TR020002/D4/LIRC

Project Name:	Manston Airport Development Consent Order
Application Ref:	TR020002
Submission Deadline:	4
Date:	8 March 2019

Manston Airport DCO: Comments on Local Impact Reports

ANNEX 3
PRoW PLAN

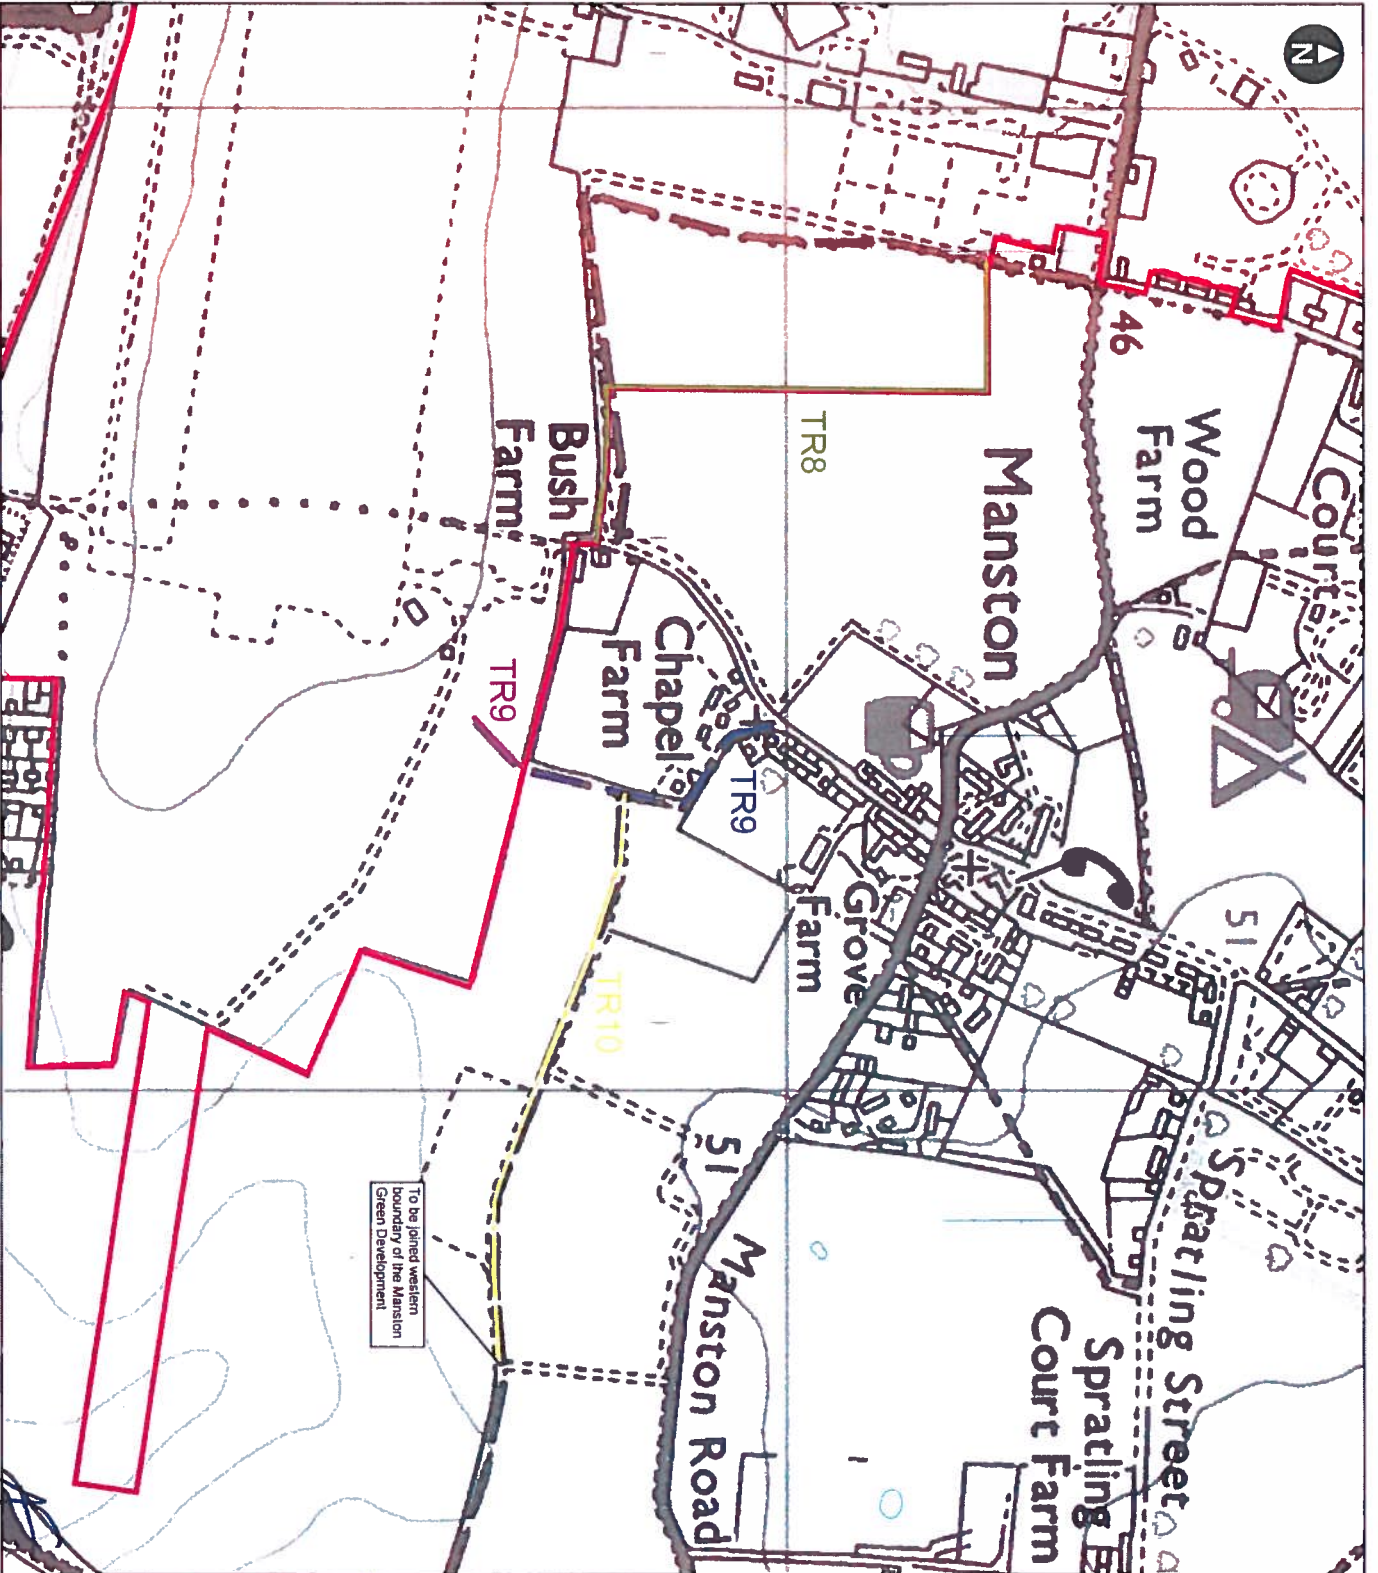
Kent County Council	Public Rights of Way	<p>Bridleway TR9</p> <p>"It is accepted that the part of the bridleway that lies within the site boundary will have to be extinguished and that it is not currently used, as it is a dead-end route.</p> <p>... the County Council requests that the additional connection to Thanet Parkway is still considered by the Applicant, as this will greatly benefit the connectivity of the site and will further increase opportunities available to the local community for recreation, active travel and exercise."</p>	<p>As identified in Section 3.4 of the PRoWMS, a new link from TR9 to the proposed Thanet Parkway Station across the site or around the edge of the site cannot be provided as part of these development proposals.</p> <p>A link across the site would present security and safety risk as it would cross the runway, taxi ways and other infrastructure. It is generally not considered appropriate to have PRoW running through airport sites as for security reasons these are fenced off with only security checks points the access onto the taxi ways and apron of the airport.</p> <p>The alternative route would be a very long route around the eastern side of the site following the perimeter fence that would potentially make it unattractive to users as it would take a long time to take this circuitous route.</p>

Local Authority	Topic	Issue	Applicants Response
			<p>The Applicant has taken advice from aviation experts, Osprey. Their recommendation was to reduce the presence of PRow near the airfield boundary (and Communication, Navigation & Surveillance) and avoid providing any PRow within the licensed boundary of the airfield.</p> <p>For that reason, it was considered, that no new links are to be created around the eastern boundary of the proposed redevelopment</p> <p>Due to the design of the Airport, Fuel Farm and housing estate off King Arthur Road, creating the link set out in emerging local plan would require third party land outside the redline of the proposed DCO application.</p>
Kent County Council	Archaeology	<p>“The County Council welcomes that the results of the geophysical survey and the evaluation trenching undertaken by Stonehill Park on the main part of the airport have become available to the Applicant for consideration in the DCO application. ... Given the detailed information now available to the Applicant, the County Council would expect greater use of the outputs to inform the discussion of the baseline and set out more precisely the archaeology known within the airfield and how it will be affected.”</p>	<p>The baseline presented in the ES [APP-033] represents an appropriate discussion to understand the effects of the proposed scheme, notably that archaeological remains across the site comprise a group of features of various periods, variously truncated by disturbance associated with the construction and use of the existing airport. While particularly significant remains were observed to the western end of the runway, the majority of remains, and those observed within the areas of greatest disturbance presented by the Proposed Development, were of a significance where effects could, in principle, be mitigated through archaeological investigation and recording. More detailed understanding of the baseline will be presented in developing detailed mitigation proposals.</p>
